**From:** Paul Troop <pault@gclaw.co.uk>  
**Sent:** 10 May 2024 17:43  
**To:** Suzanne Taylor  
**Cc:** Mark.Knighting@activetravelengland.gov.uk; White, Joy - Oxfordshire County Council; Plater, Roger - Oxfordshire County Council; Catherine Hickman; Planning  
**Subject:** Objections Himley Village 23/01493/REM  
**Importance:** High

Bicester Bike Users' Group (BBUG) has serious concerns with the detail of this planning application and also with the failure of the highways authority Oxfordshire County Council (OCC) to identify many of the shortcomings of the design from the perspective of walking and cycling, notwithstanding that these shortcomings were previously identified by the previous OCC officer and the national expert body Active Travel England (ATE), and remain outstanding.

TITLE  
**S278 OFFSITE HIGHWAY WORKS  
 PRIMARY ACCESS JUNCTION  
 GENERAL ARRANGEMENT  
 SHEET 1**

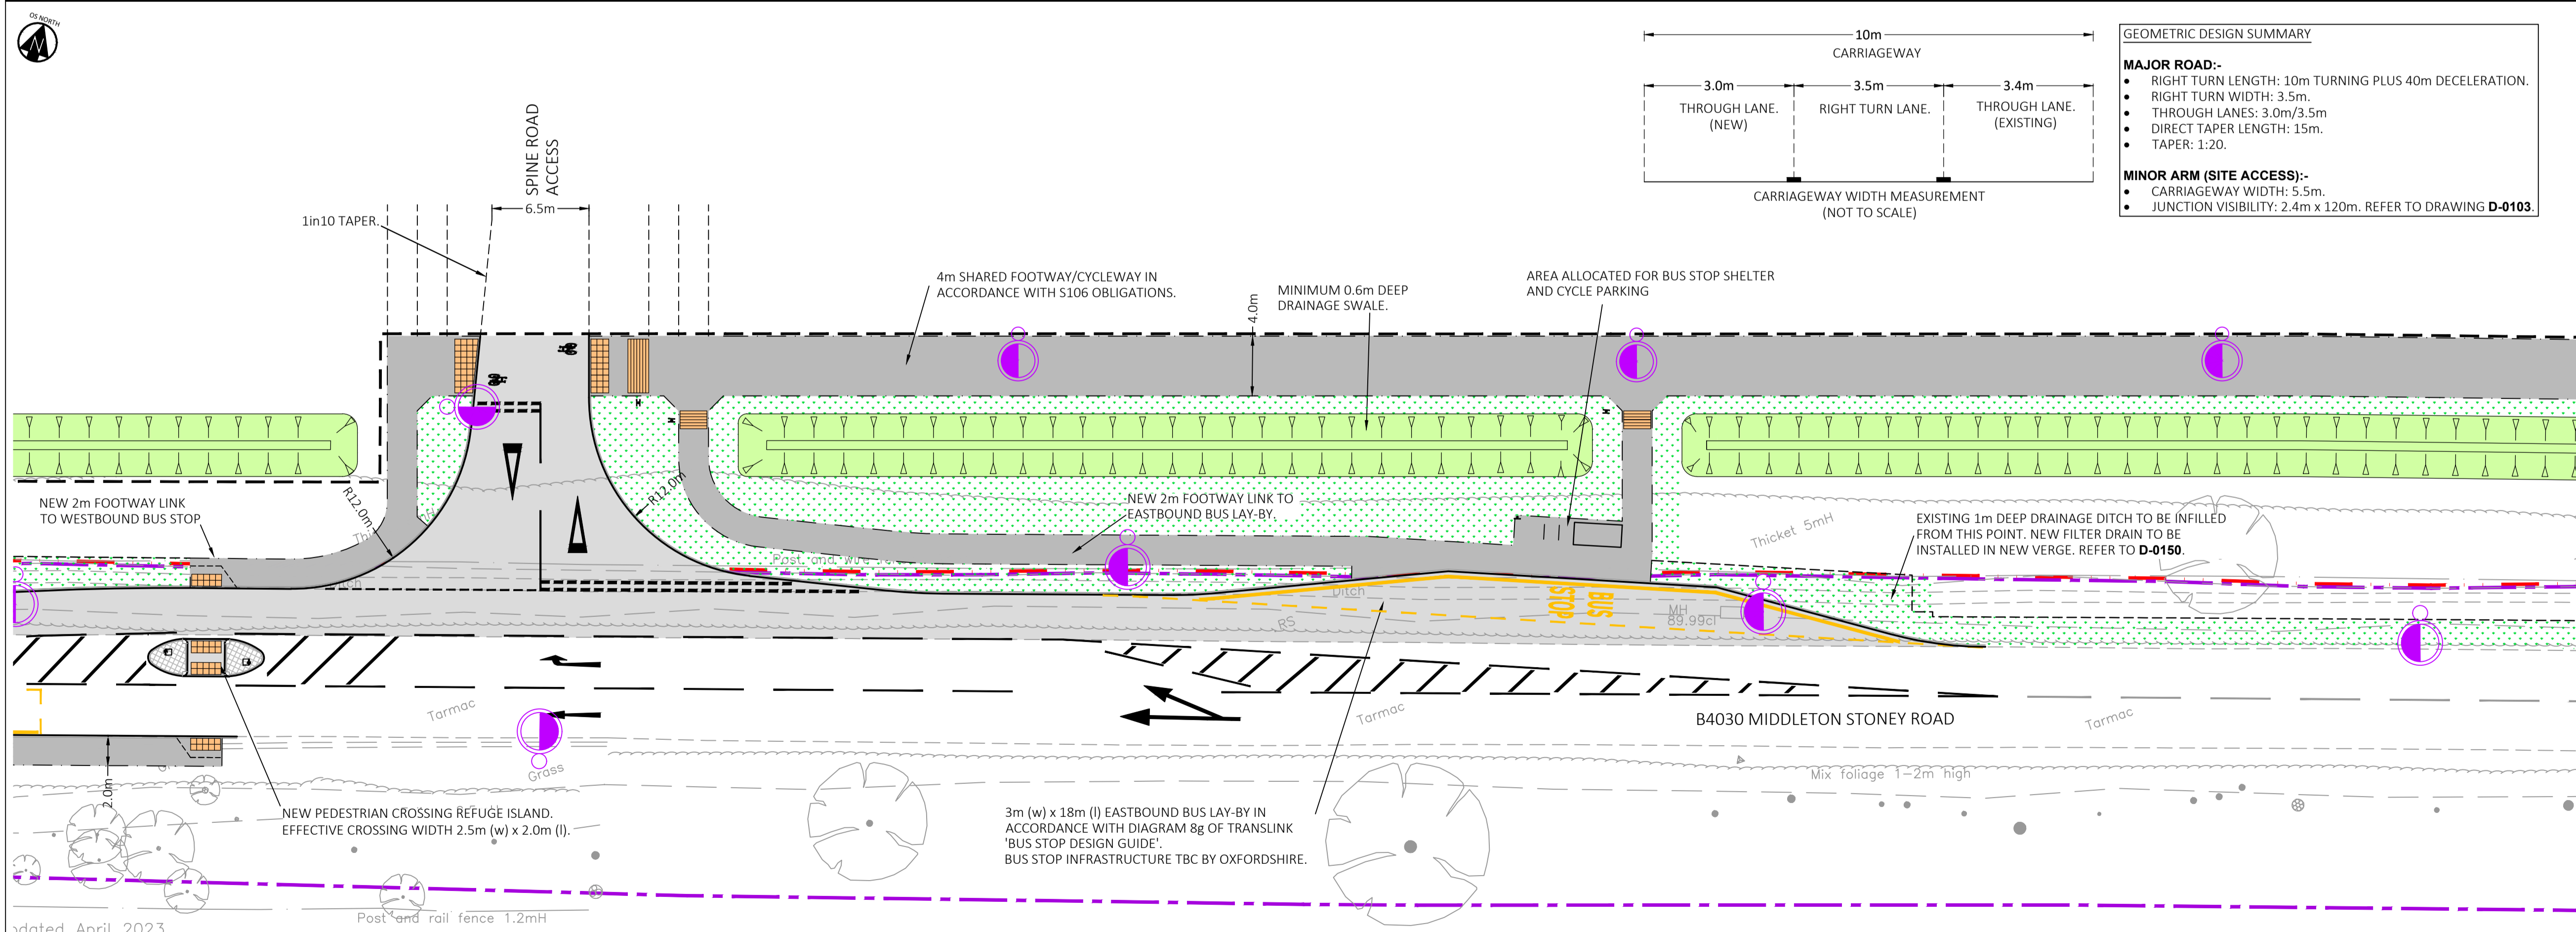
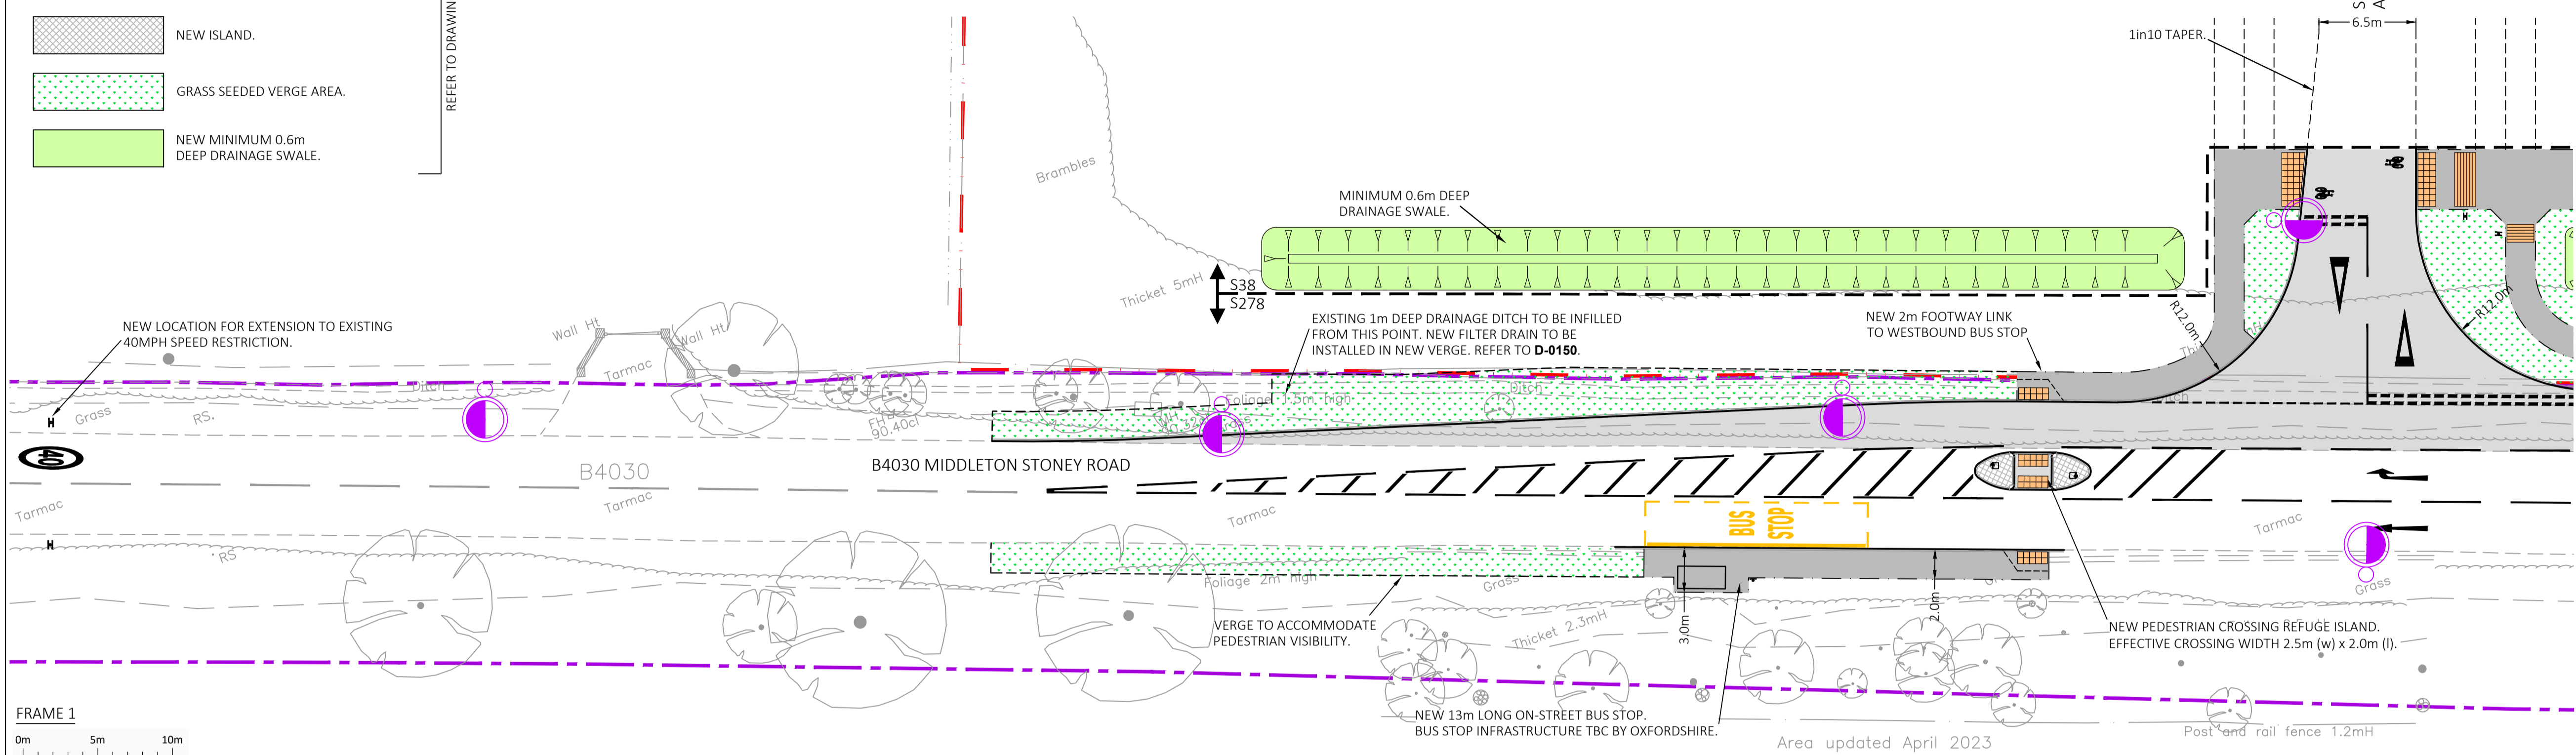
4. The proposed uncontrolled crossing over the B4030 will exclude most users as per LTN 1/20 Table 10-2 and should be replaced with a signalised crossing.

TITLE  
**S278 OFFSITE HIGHWAY WORKS  
PEDESTRIAN/CYCLE LINK  
GENERAL ARRANGEMENT  
SHEET 3**

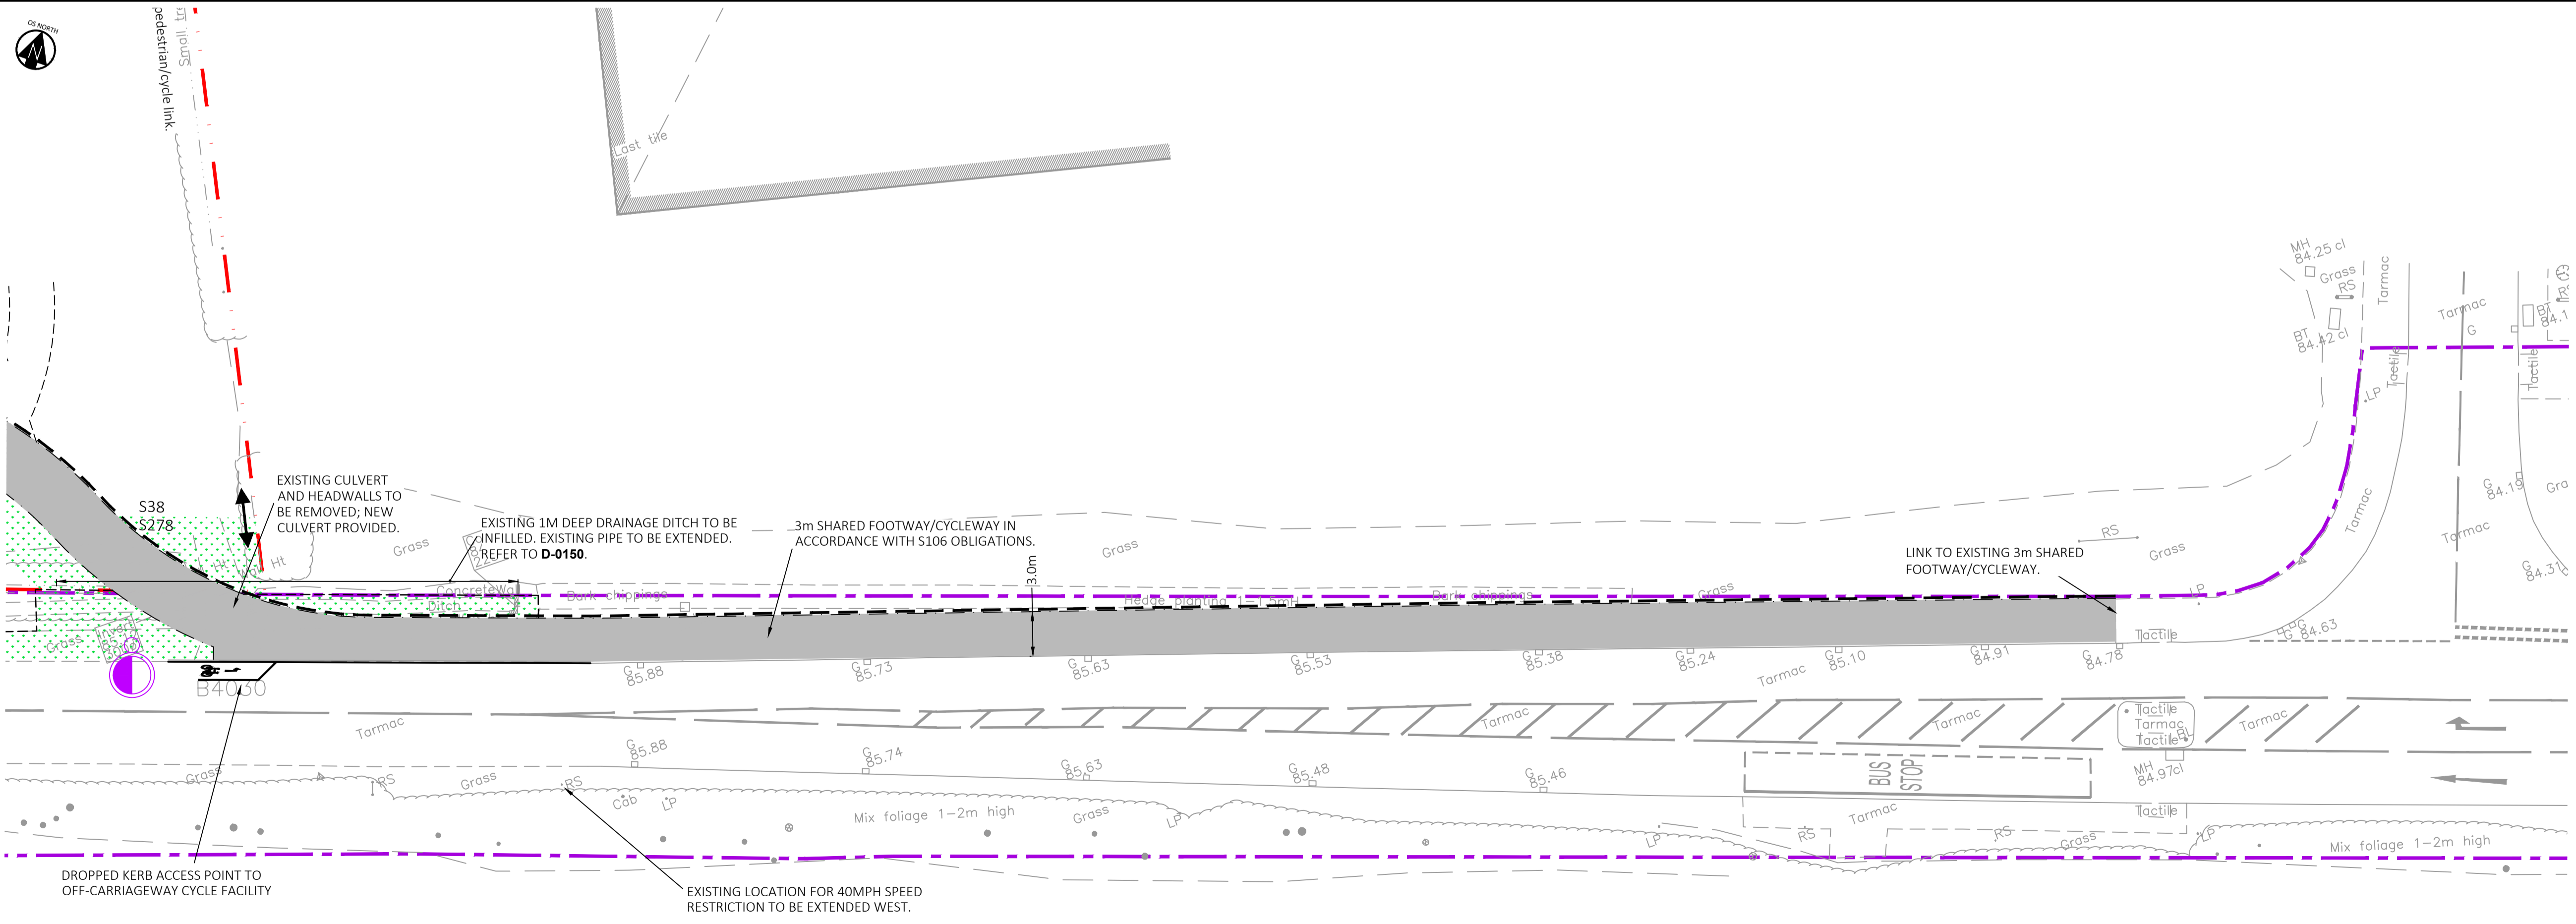
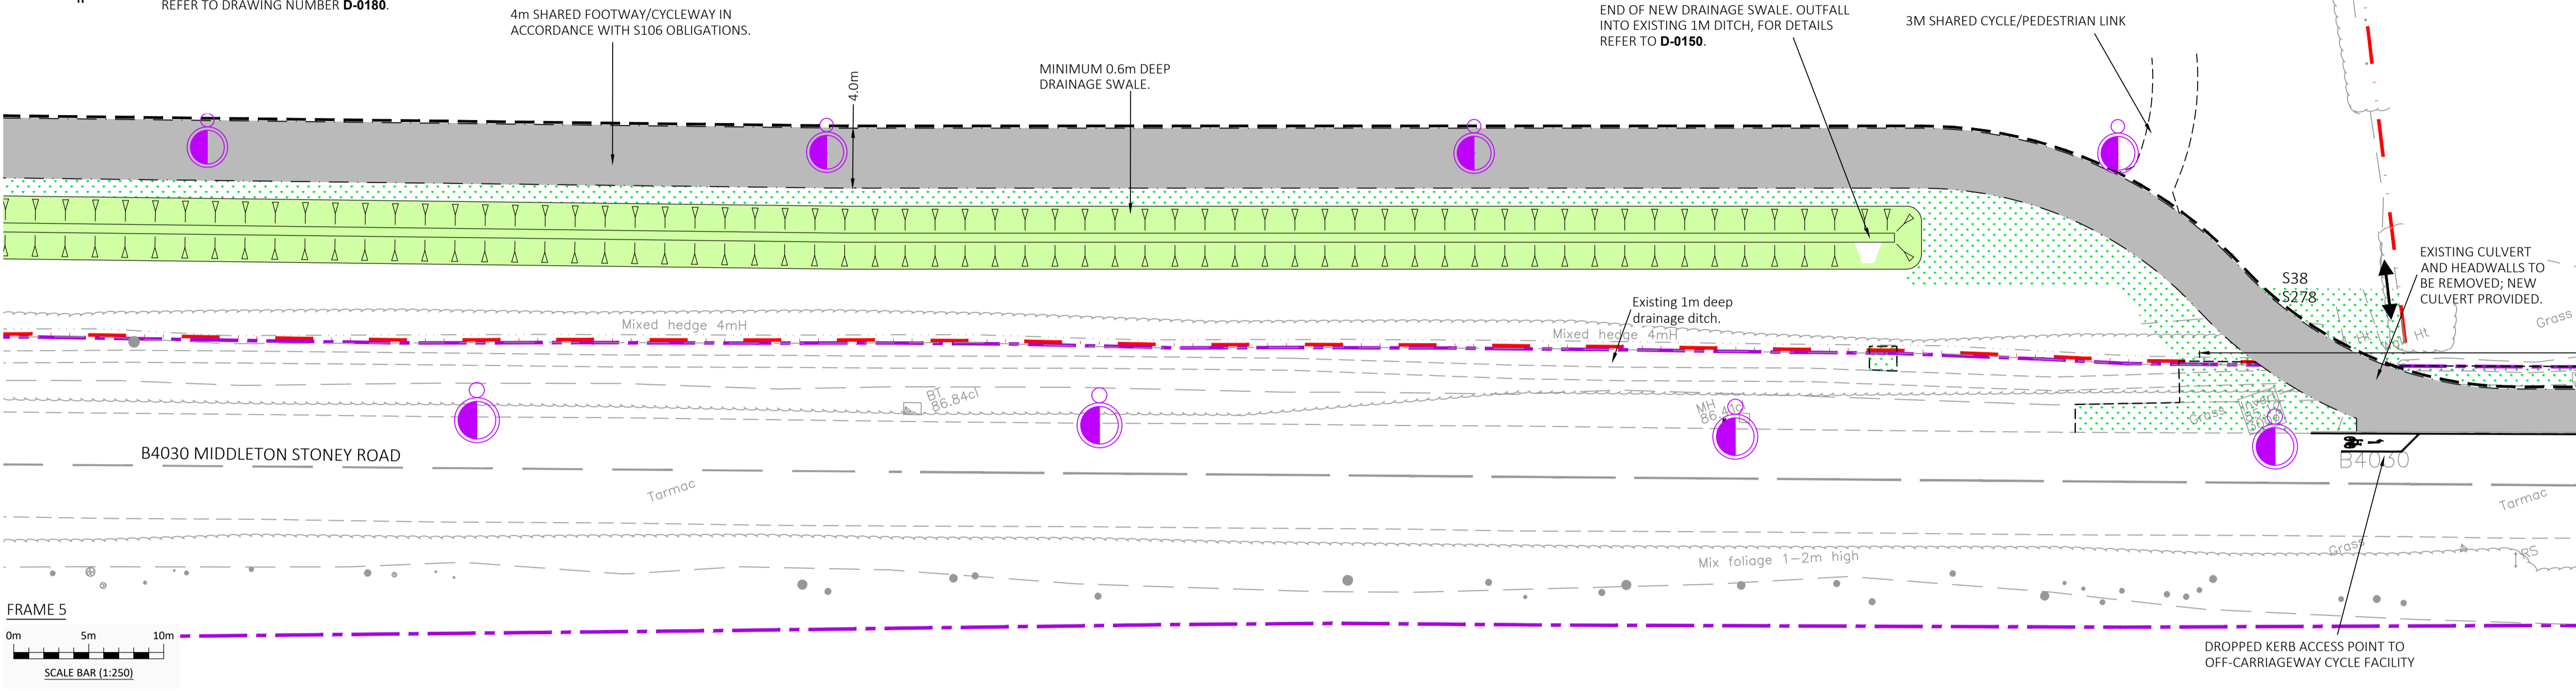
2. Cycle provision is required on both sides of the Spine Road East-West, as per LTN 1/20 and the OCC Cycle Design Standards [2.2.6].
3. Access to the site requires a minimum of 1m horizontal buffers from the motor vehicle carriageway in accordance with LTN1/20 Table 6-1 and OCC's own Cycle Design Standards [3.2.7], and ideally also segregation between pedestrians and cycles.
